Meeting:	Major Applications Planning Committee	
Date:	Wednesday, 15th July 2020	Time: 6:00pm
Place:	Committee Room 5, Civic Centre, Uxbridge

ADDENDUM SHEET

Item: 6	Location: Former Star Public House
<i>Amendments/Additional Information:</i>	<i>Officer Comments:</i>
Replace Drw. Nos. 1664/21/B/05 and 1664/21/B/15 Version 23 with the Version 23 plans received on 13/7/20.	The applicant has submitted an amended first floor plan and north elevation for Block A which clarify that there would be step free access to the communal amenity space.

1 Block A - First Floor Plan
Scale: 1:100

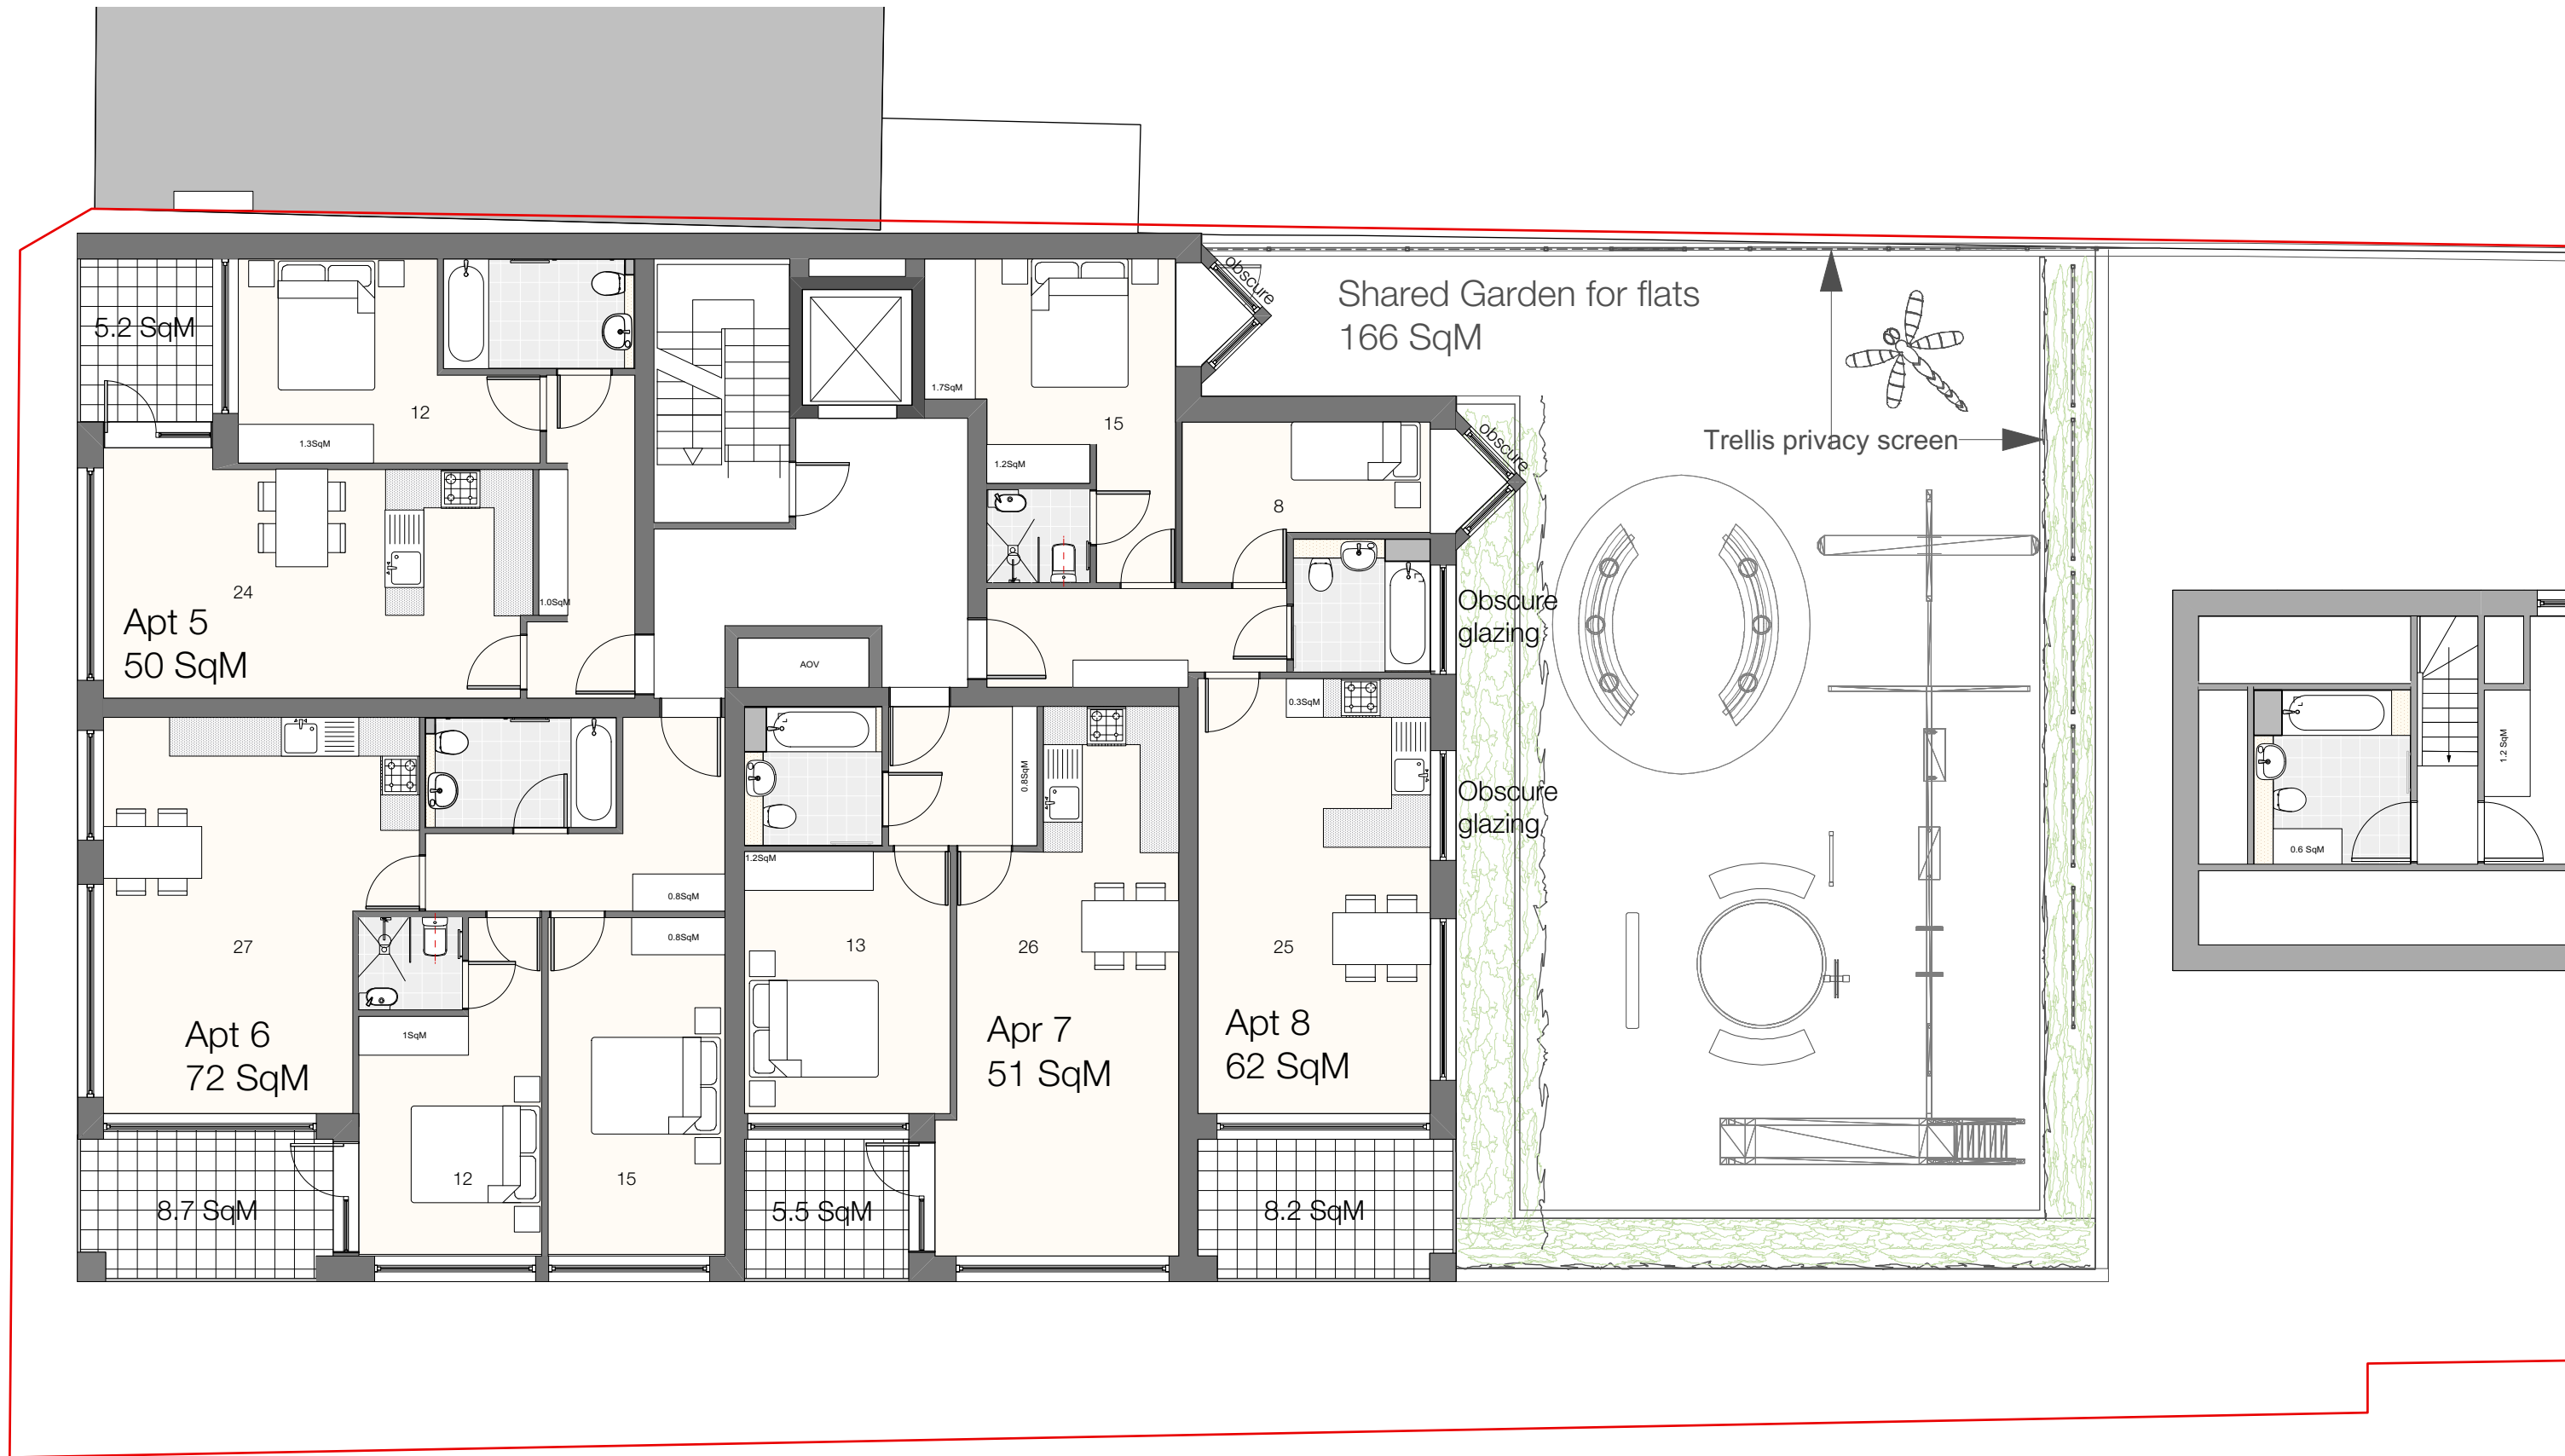
Item: 7	Location: Former Star Public House
<i>Amendments/Additional Information:</i>	<i>Officer Comments:</i>
Replace Drw. Nos. 1664/A/05 Version 22.1 with Version 23 and 1664/A/14 Version 22.1 with Version 23 both received on 13/7/20 and in Condition 2 (Accordance with Approved Plans).	The applicant has submitted an amended first floor plan and north elevation for Block A which clarify that there would be step free access to the communal amenity space.
